From: Jennifer Ballinger <Jennifer.Ballinger@Cherwell-DC.gov.uk>
Sent: 15 May 2020 12:48
To: Gemma Magnuson <Gemma.Magnuson@cherwell-dc.gov.uk>
Subject: 20/00855/DISC and 20/00879/DISC

20/00855/DISC – condition 3

20/00879/DISC – condition 6

2018-1014-GA02 **SERVICE MARKUP**

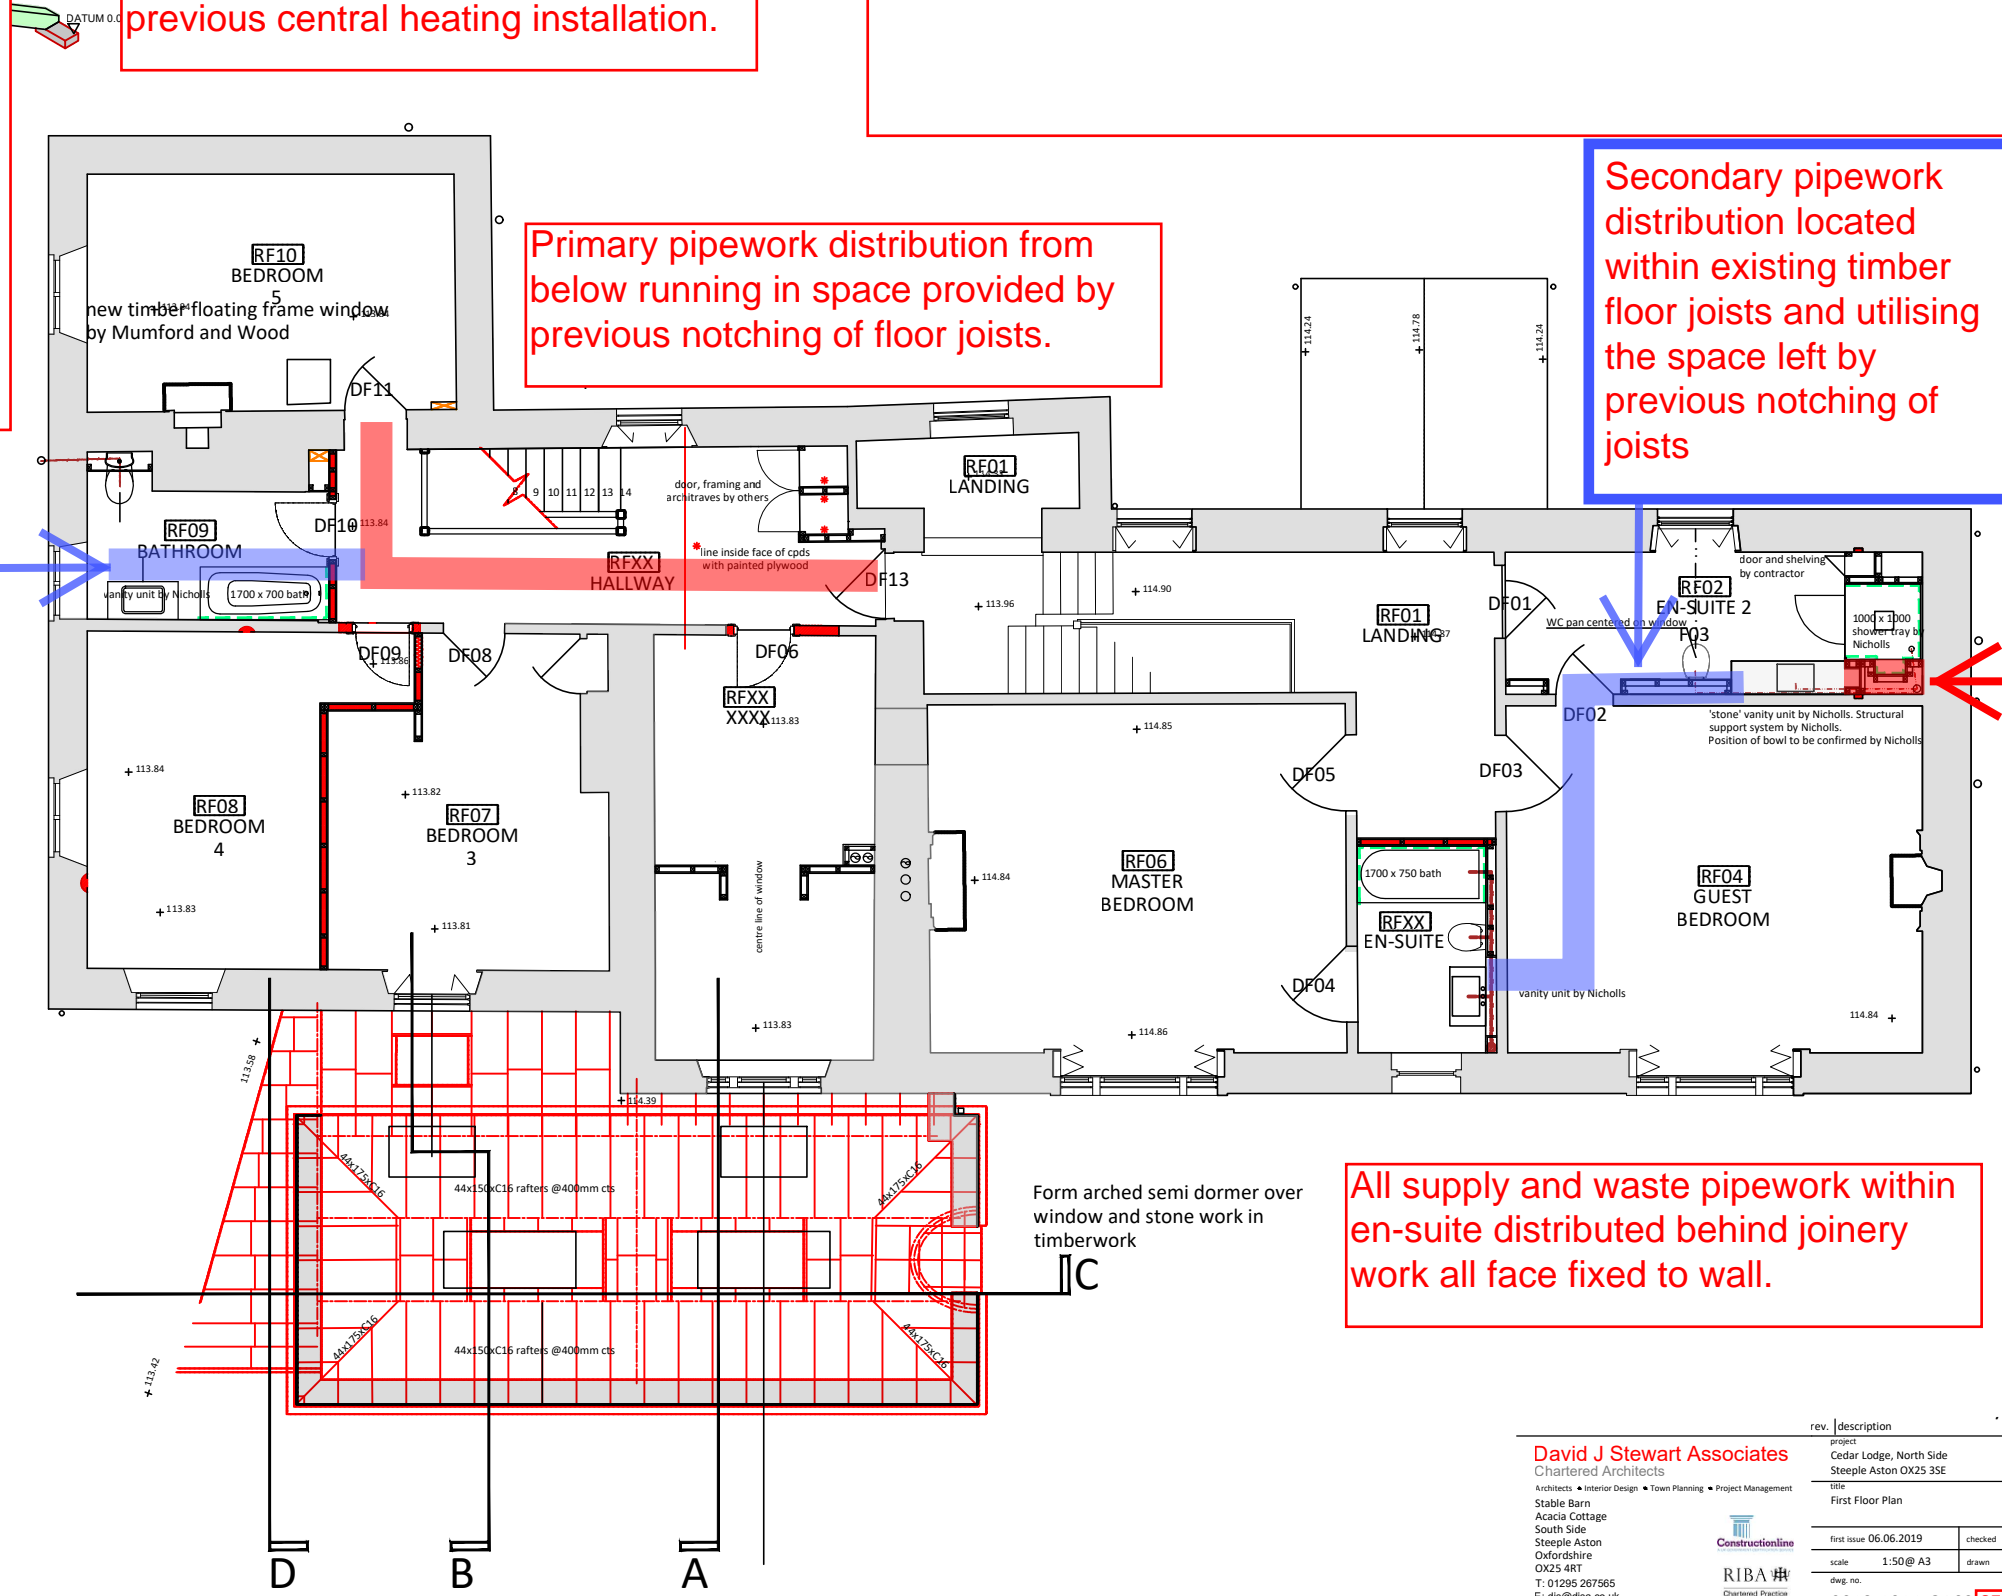
The plans appear to indicate that the new plumbing will be set within newly constructed joinery and will not impact on historic fabric. The soil and vent pipe is to be brought down through the existing floor on the interior of the building and will not breach through the rear wall of the building. It is assumed that the existing window provides sufficient ventilation and that no additional ventilation is required. It may be useful to have a paragraph from the agent confirming this. There would be no objections to the discharge of condition if the impact on historic fabric is limited to the insertion of the soil and vent pipe.
